PORTLAND MAINE

April 29, 2013

Re: 45 Summer Street – 058-A-032 – R-6 Residential Zone – Permit #2013- 00720 New Single Family Home

SITE, UTILITY, GRADING & DRAINAGE PLAN

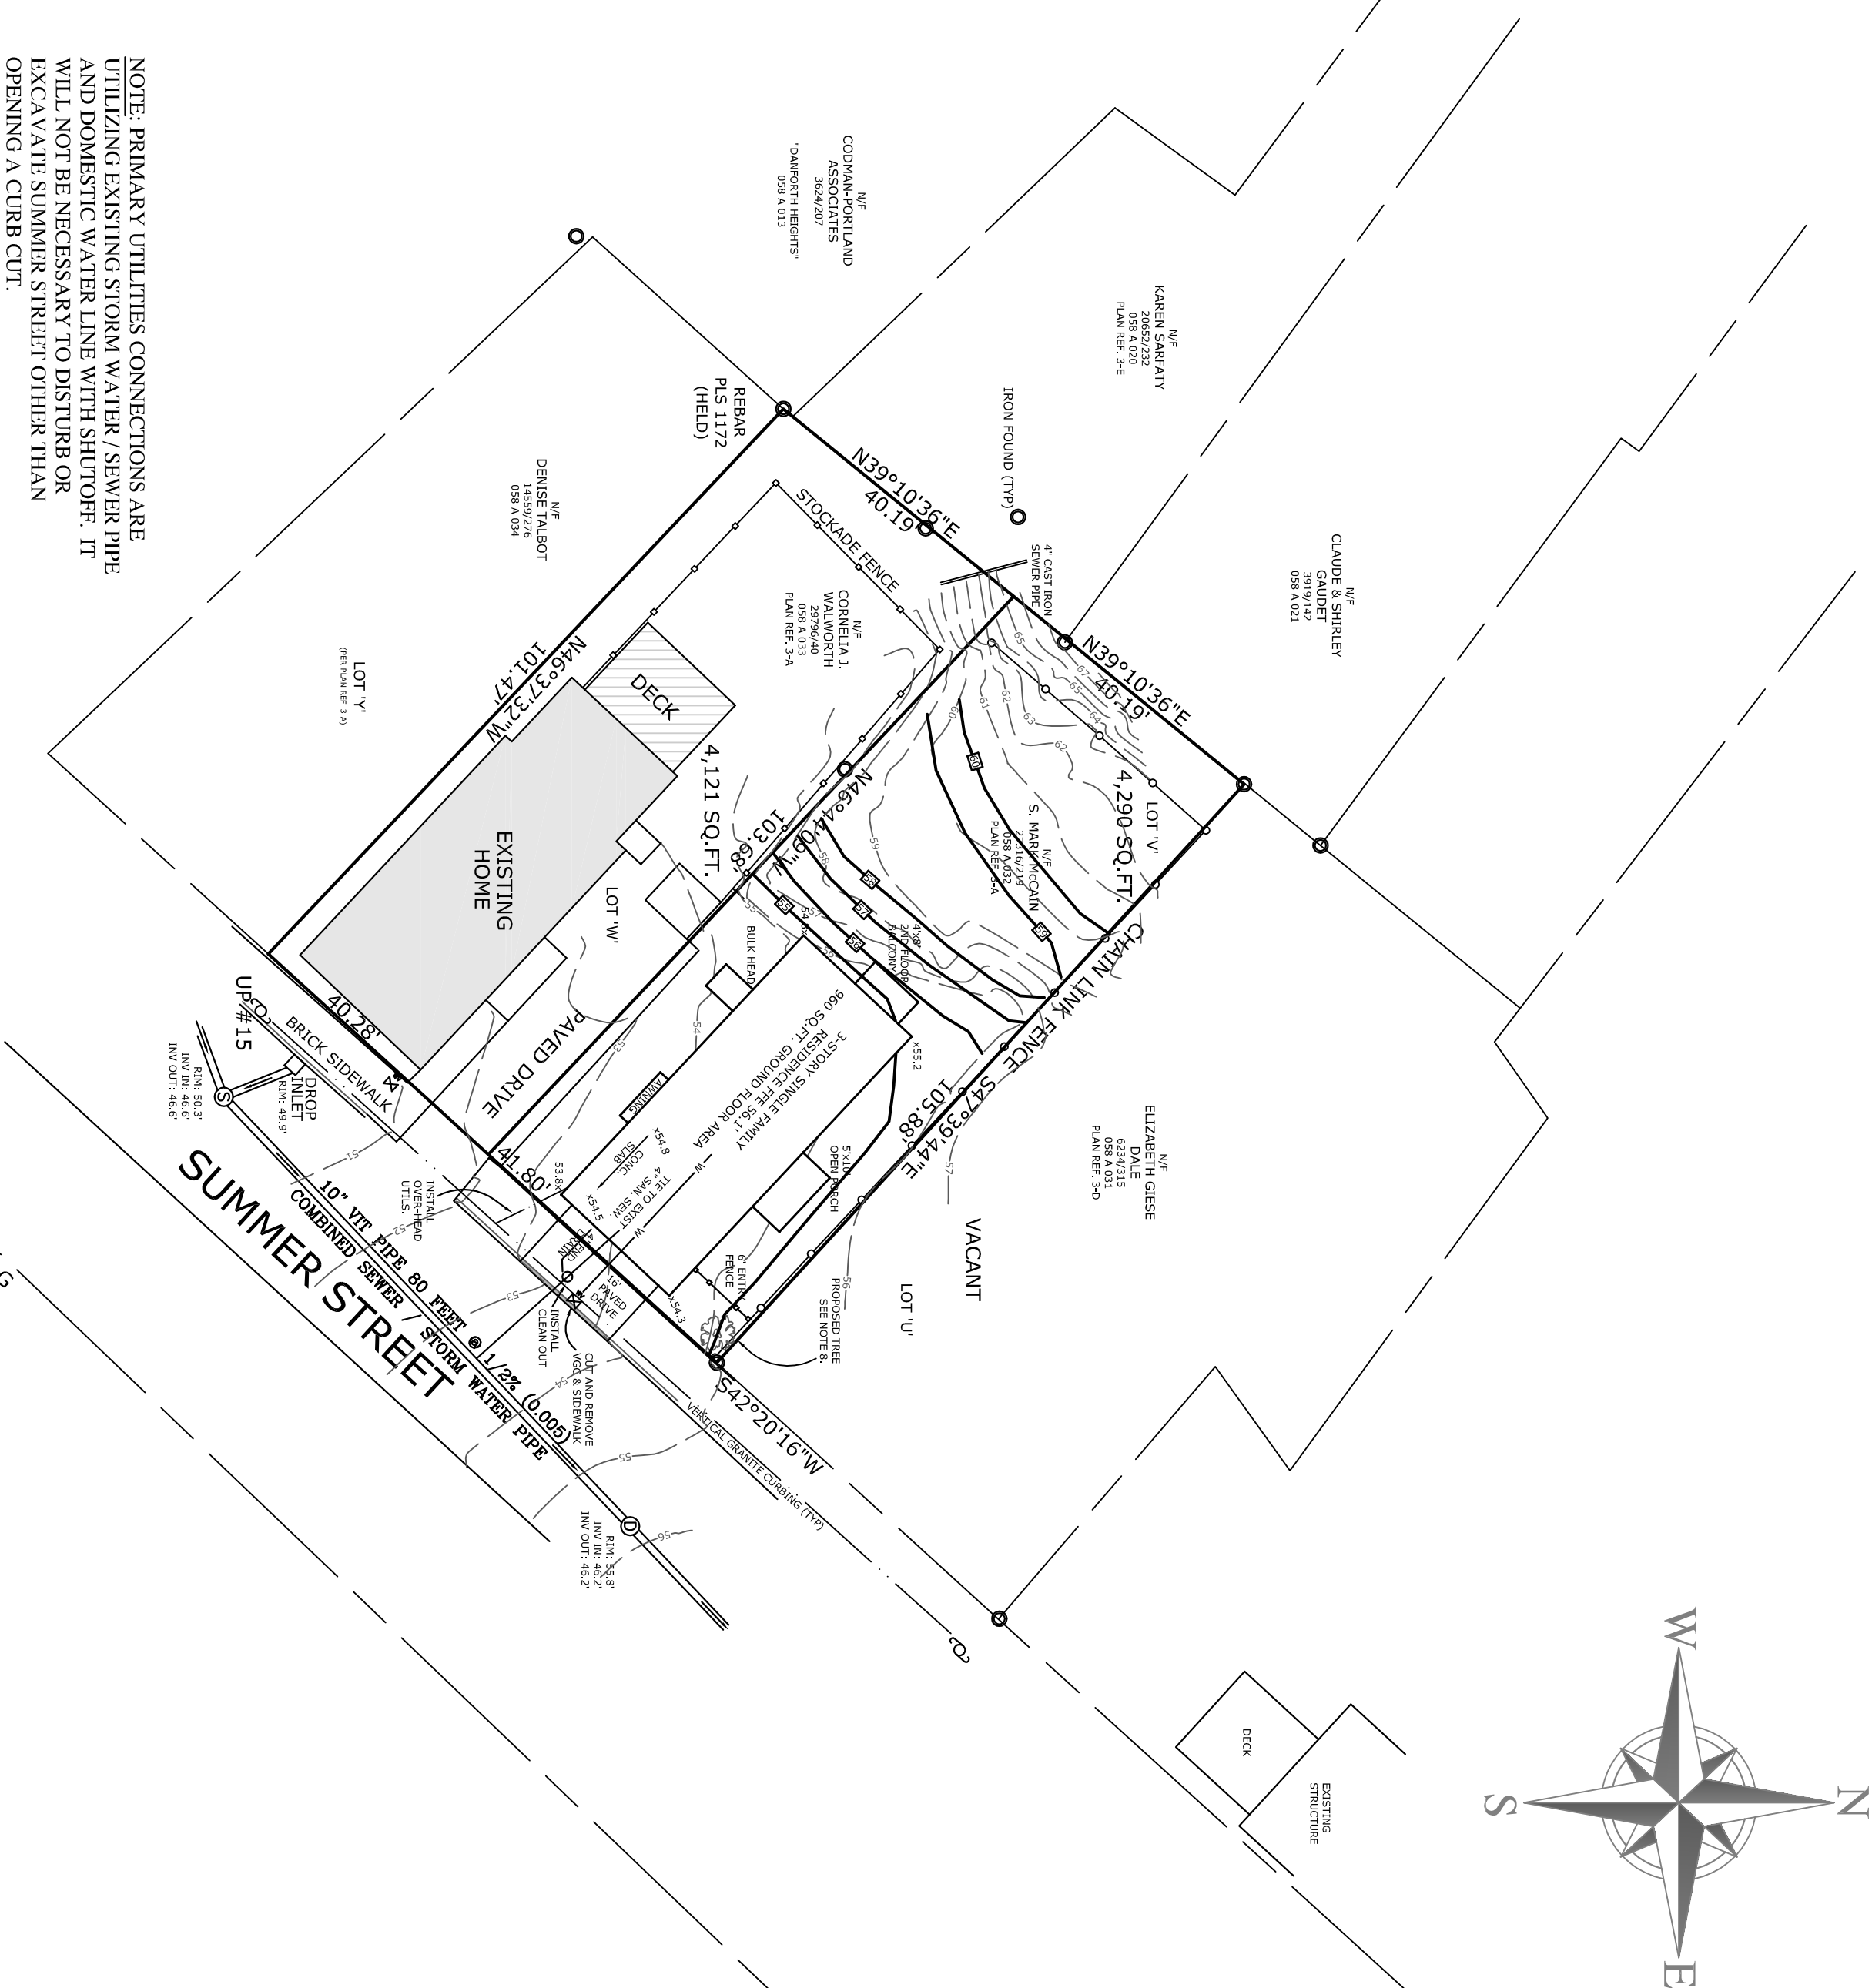
The lot at 45 Summer Street meets the minimum lot size and street frontage requirements for a lot of record. The R-6 yard dimensions are outlined in section 14-139a(4). The proposed house meets the required rear and side yard setbacks, but it does not meet the required front yard setback. Section 14-139(a)(4)(a) states that the minimum setback for the front yard is ten feet, but “a front yard need not exceed the average depth of front yards on either side of the lot”. The front yard for the lot to the left of 45 Summer is setback 2.2 feet from the property line. The lot to the right of 45 Summer is vacant so the minimum front yard setback of ten feet must be used to obtain the average depth of the front yards on either side. The average of 2.2 feet and 10 feet is 6.1 feet. Therefore the front yard for 45 Summer Street needs to be a minimum of 6.1 feet from the property line. The proposed house scales at 2.7 feet. Since the minimum front yard setback is not being met, I must deny the building permit at this time.
